## **Development Facilitation Team (DFT) – Review Comments**

**Project No: PR-2023-009209 Date: 03/06/2024    Agenda Item: #2    Zone Atlas Page: NR-BP**

**Request: Proposing A 93K GSF Expansion of an existing 90K GSF Manufacturing Warehouse at 6625 Bluewater Road NW. This will include improvements for additional Onsite Parking, Onsite Drainage Features, Landscape, Lighting, and Wet Utilities.**

**Project Name:** 6625 Bluewater Rd. Warehouse Expansion

OVERALL ELEVATION - SOUTH - SDP

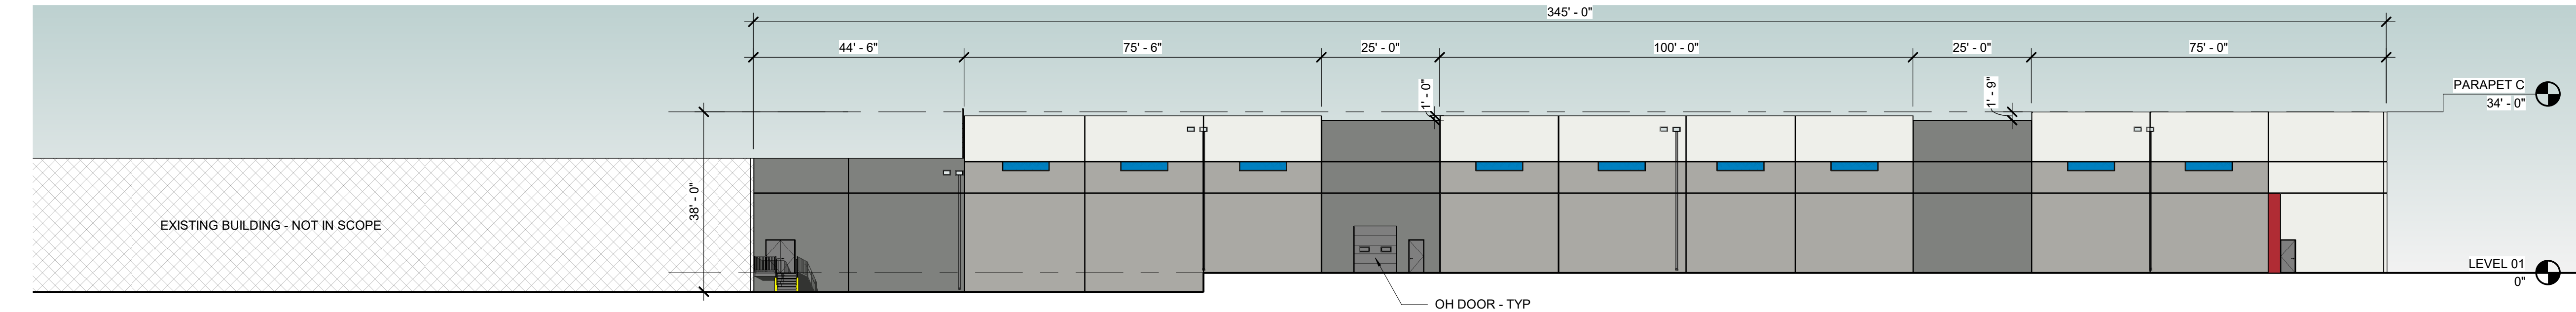
Please explain how the south facing façade is meeting these requirements. It does not appear that the street facing façade (south) is meeting minimum façade requirements. **\*Completed\***

SHEET
C5.0

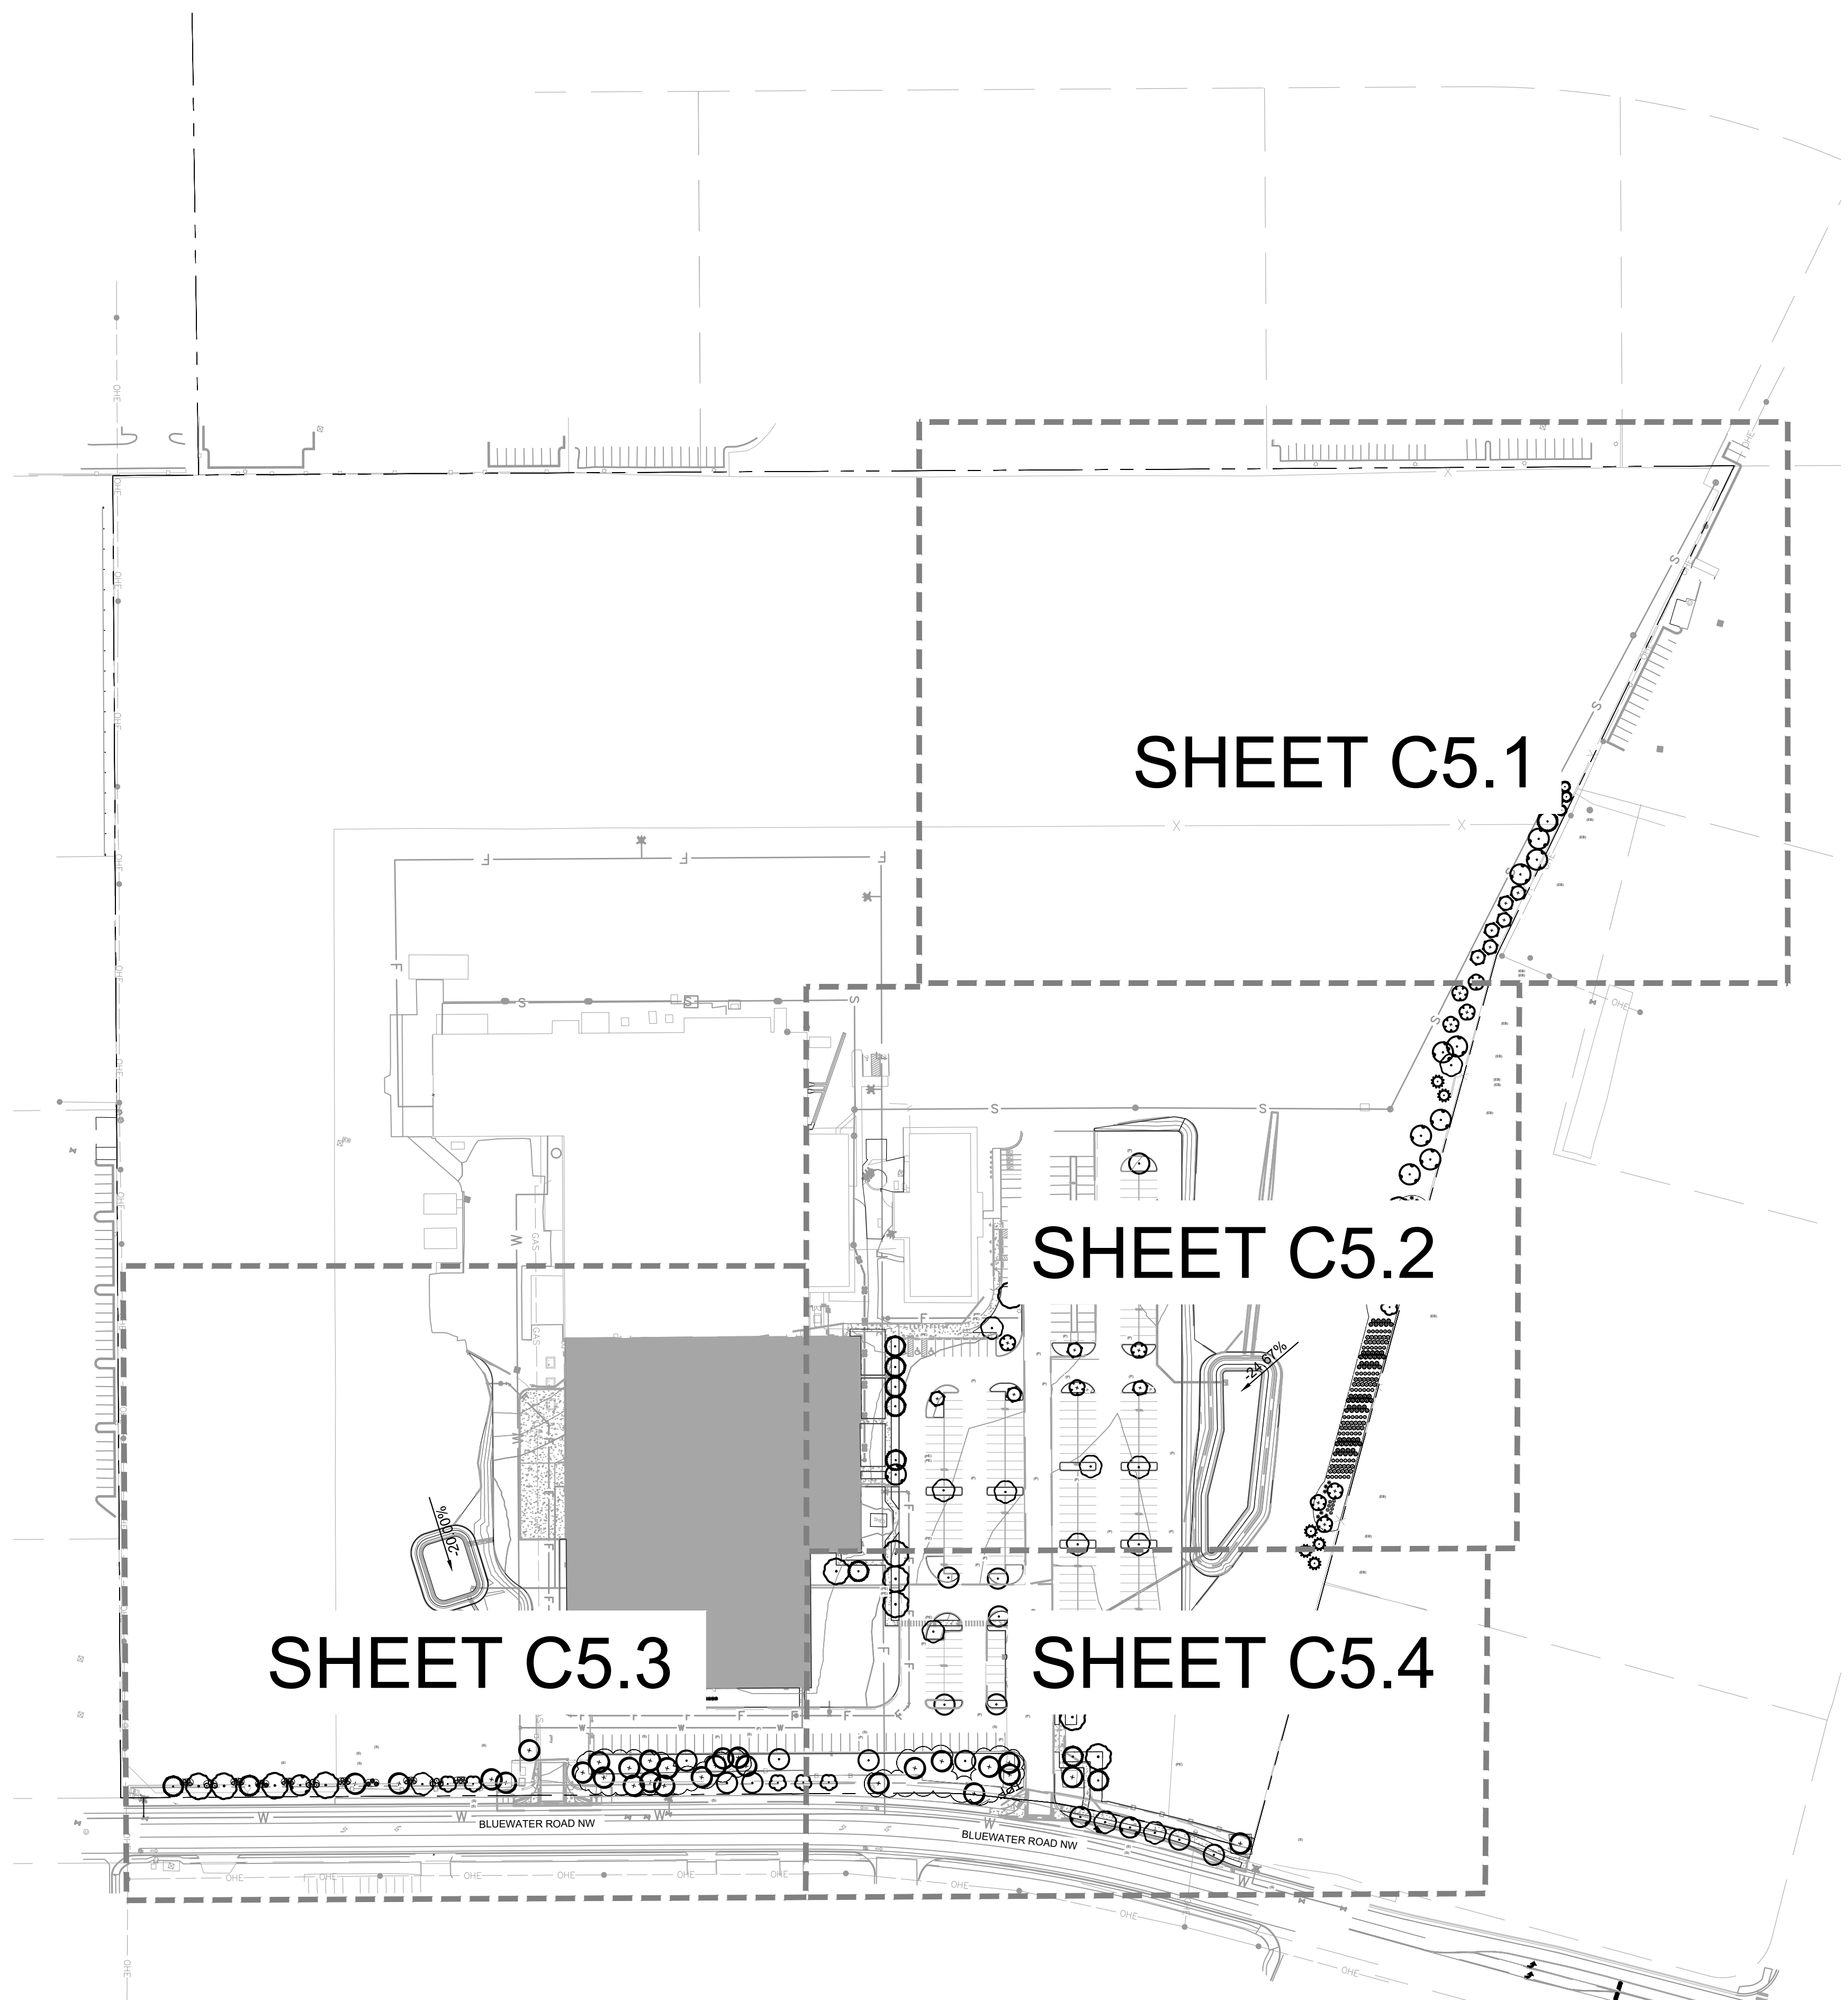
1. For primary buildings containing a use from the Transportation subcategory of Commercial Uses or from the Industrial Uses category in Table 4-2-1, at least 1 outdoor seating and gathering area shall be provided that is a minimum of 500 square feet. It does not appear this requirement is being met. Please show minimum 500 SF gathering area including seating on Landscape Plan.

Site Plan notes existing area. **\*Completed\***
